From: Maria Tomalova
Sent: 17 March 2022 09:41
To: Planning.Responses
Subject: FW: M/21/22/NMA
Attachments: 06A Prop Elevs A1.pdf

As discussed, please find attached the amended elevation drawing with one of the kitchen skylights removed.

Ground Floor Plan -
Proposed

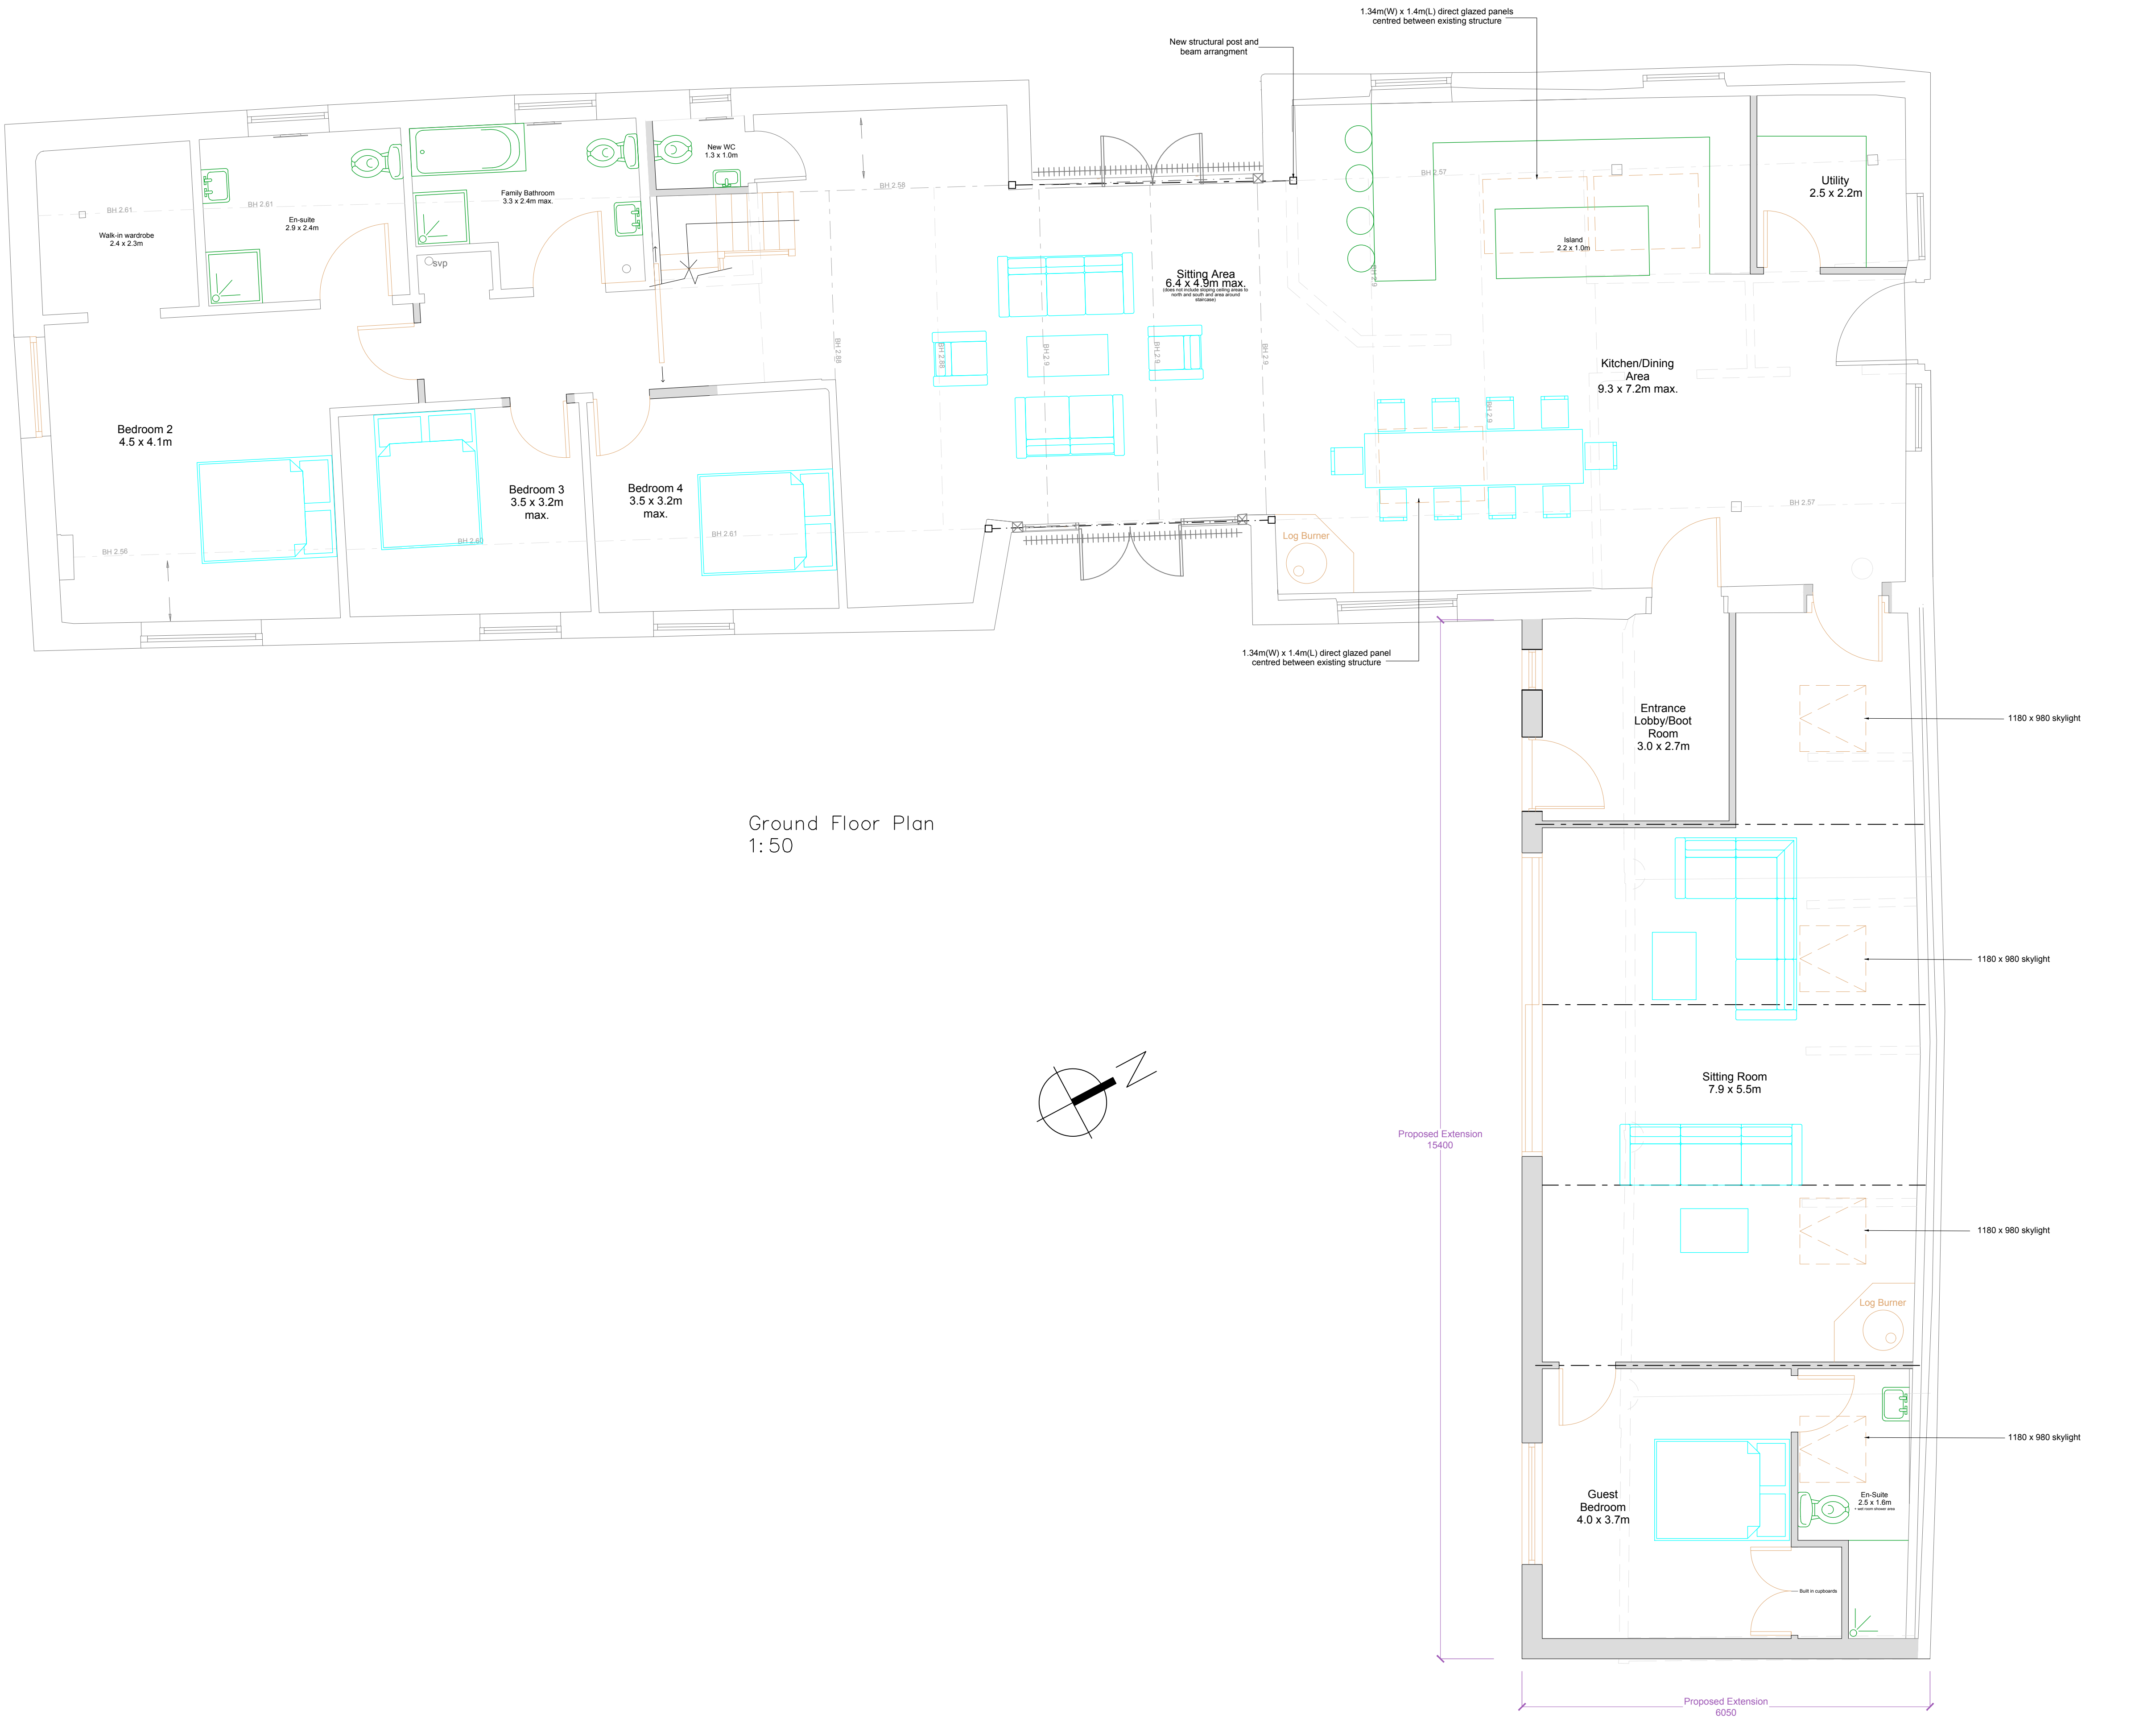
Position of chimney in front of roof light; and why the roof-lights are not the same whilst they are sitting next to each other?
